Date: 27-Oct-2025  
Our Ref: 2025/92557

**Discharge of details reserved by condition 13 (surfaced and drained areas) on  
previous permission 2021/91150 for erection of 4 detached dwellings  
rear of, 66, Child Lane, Roberttown, Liversedge, WF15 7QG  
Application Number: 2025/92557**

Drawing Title
PROPOSED SITE LAYOUT

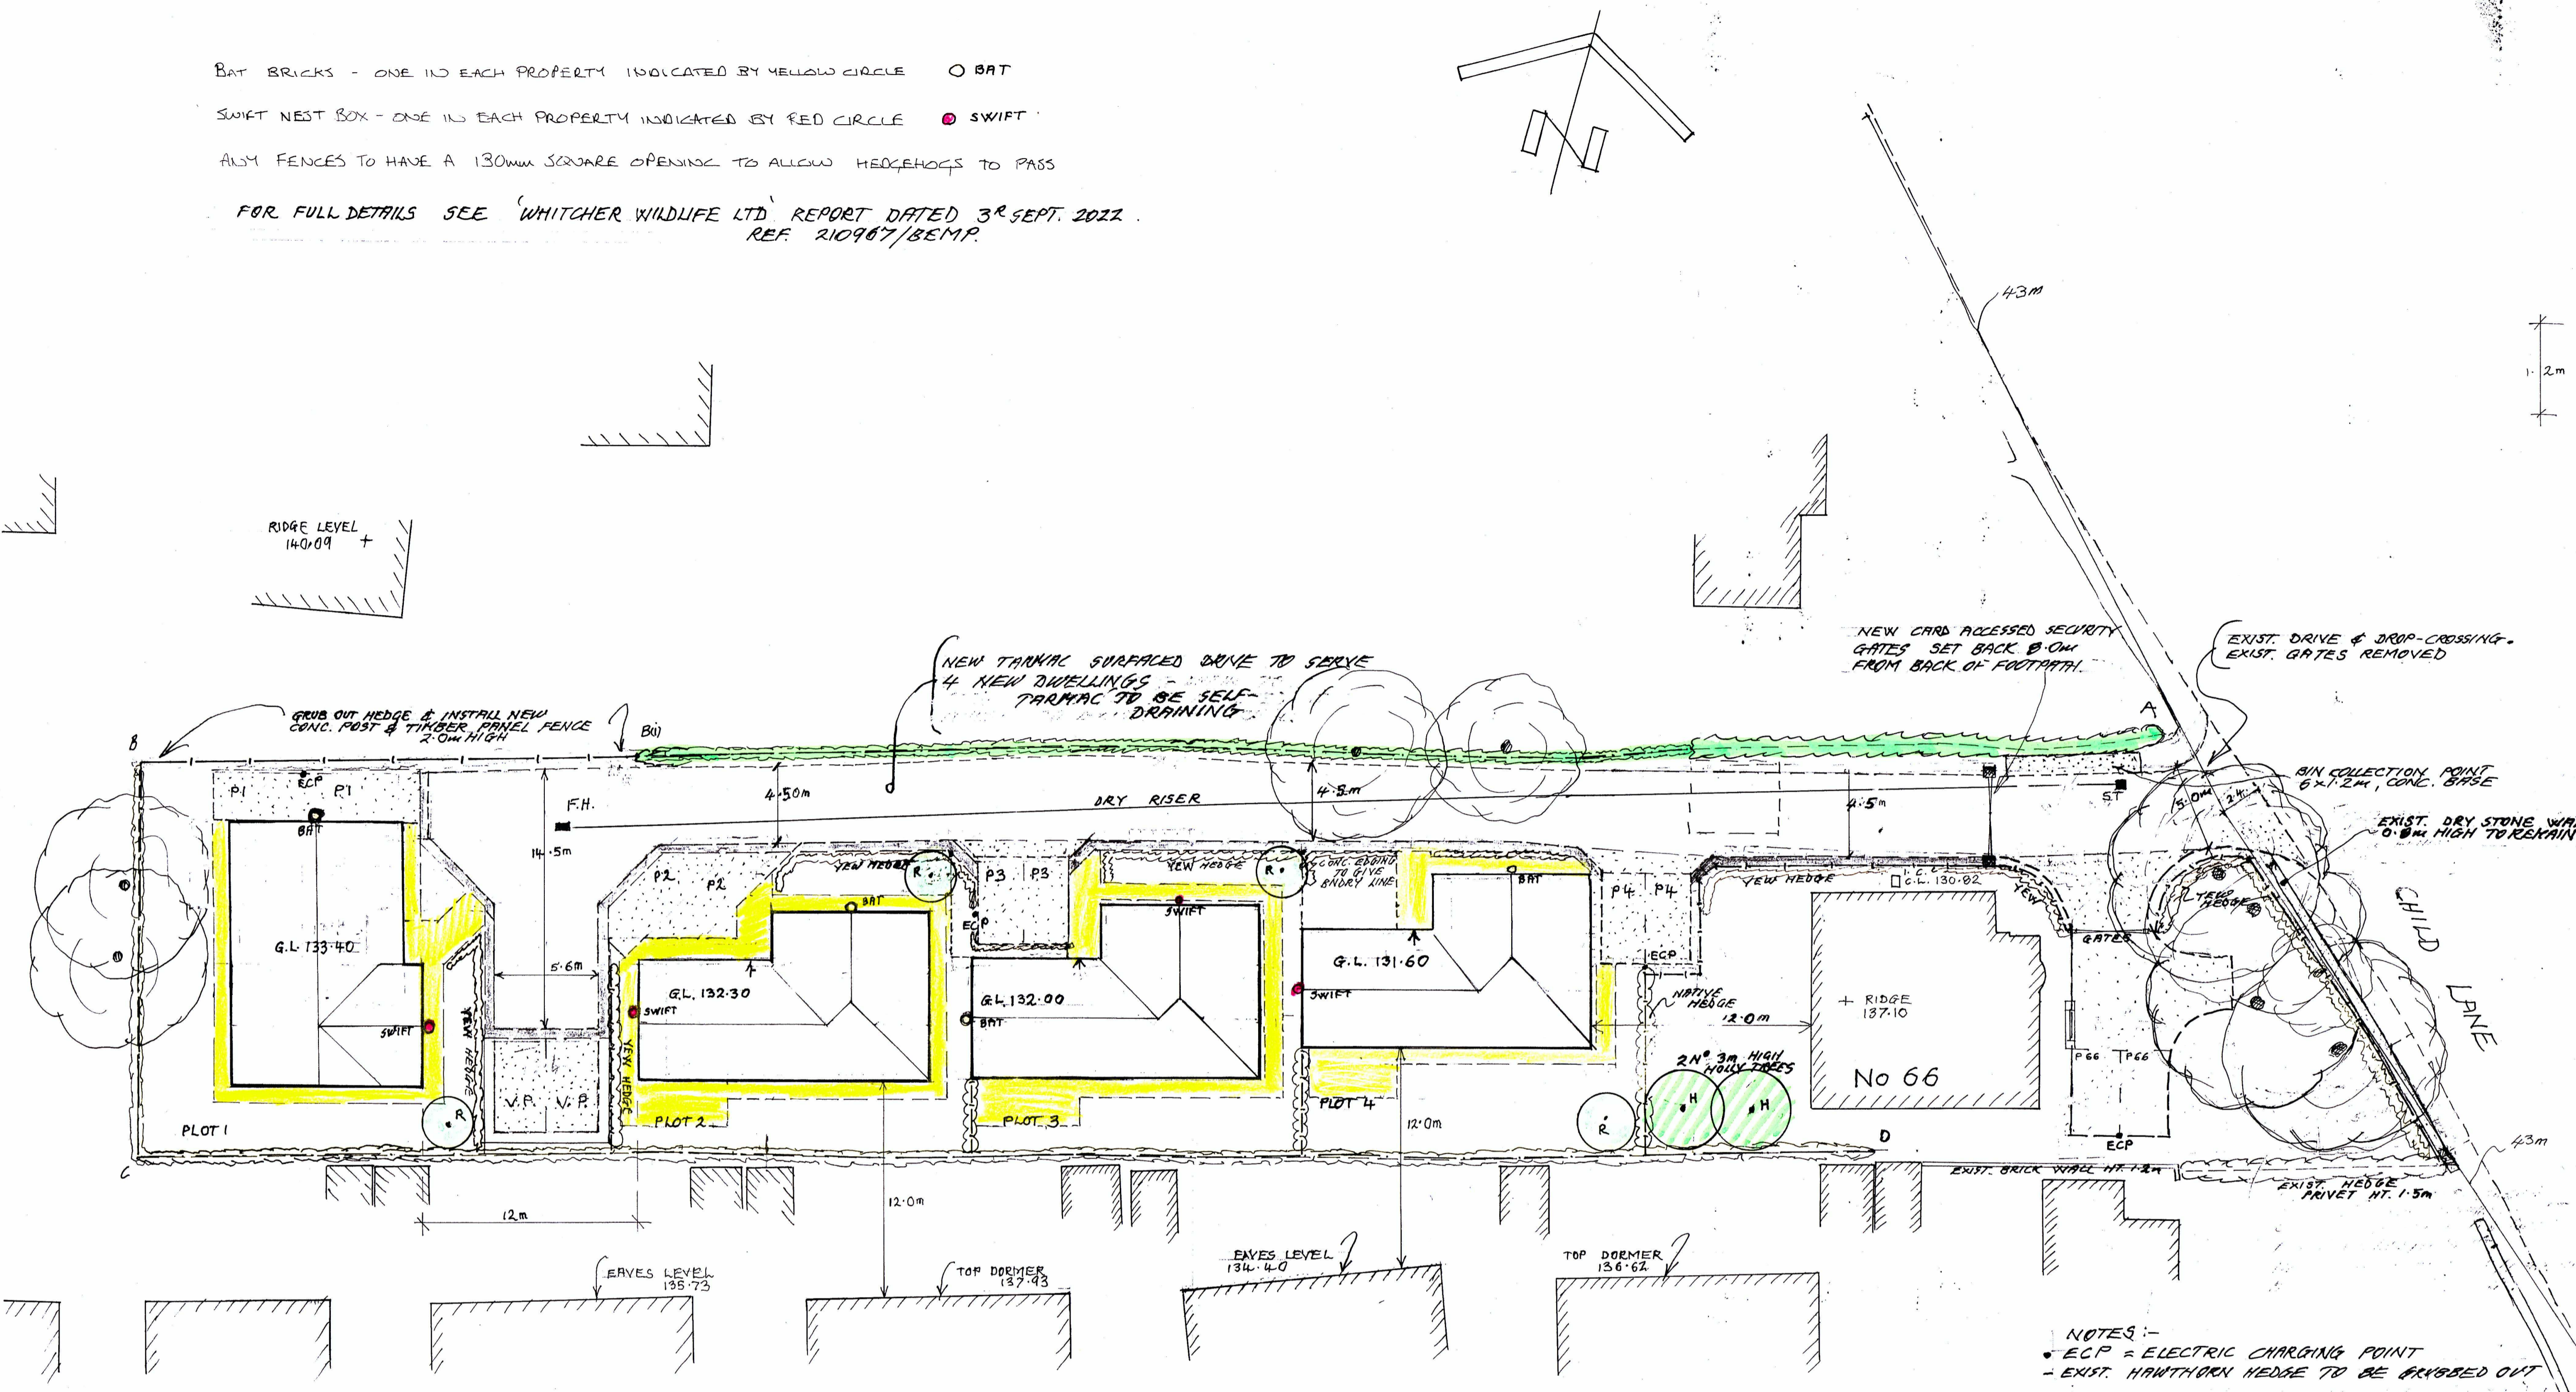
Drawing No 20/207/4 Rev C Proposed Site Layout shows that the vehicular/pedestrian areas serving the 4 new dwellings are to be surfaced with a self-draining tarmac. The covering letter confirms this adding that the self-draining tarmac surfacing is permeable. The surfacing details have been approved by Kirklees Building Control. Kirklees Highway Development Management have confirmed the details provided are suitable for the purpose of discharging Condition 13. The condition will be discharged following implementation in accordance with the details approved.
